CITY OF ALBUQUERQUE

May 2, 2024

**RE: Cactus Patch Plaza
7801 La Morada Place NW
Grading and Drainage Plan
Engineer's Stamp Date: No Date
Hydrology File: H10D034**

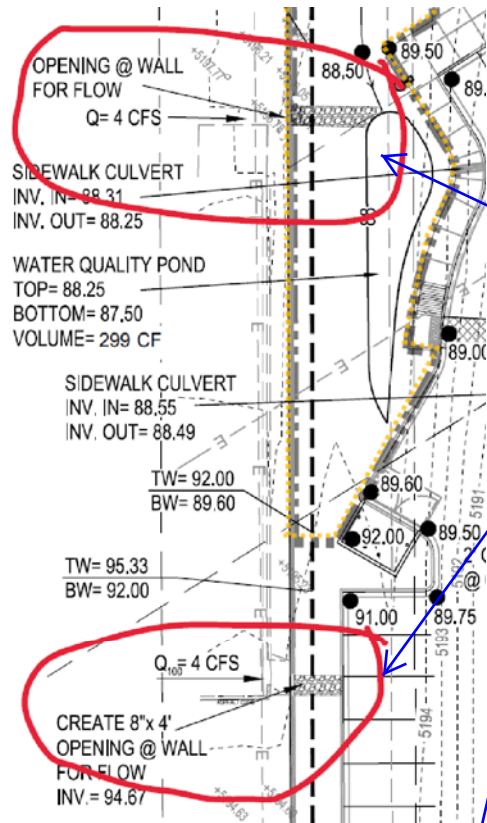
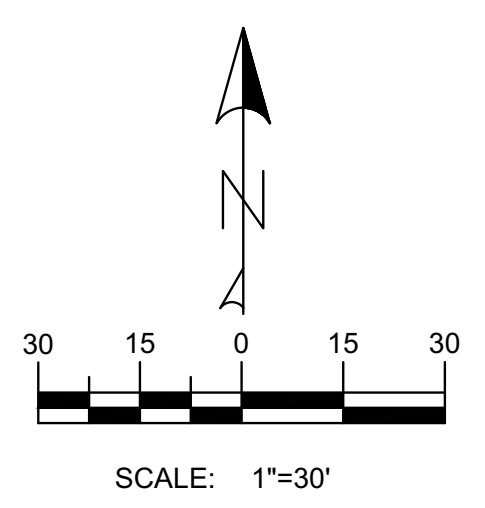
2. Please provide a section for this opening in the retaining wall. Also, please provide the opening calculations per the weir calculations, per DPM Article 6-16(A).

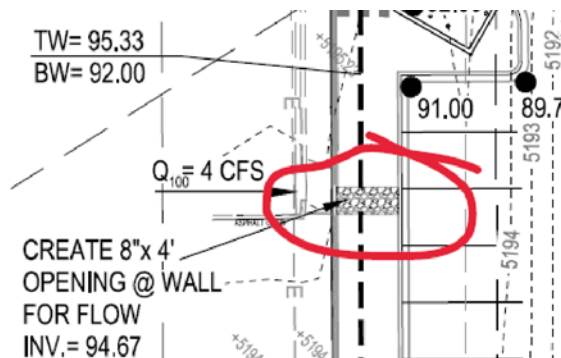
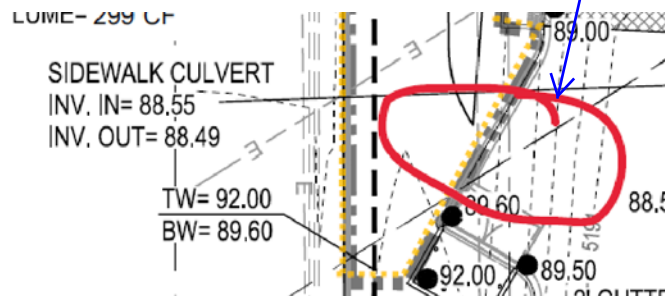
3. Please provide a curb cuts for the offsite flows (4 cfs).
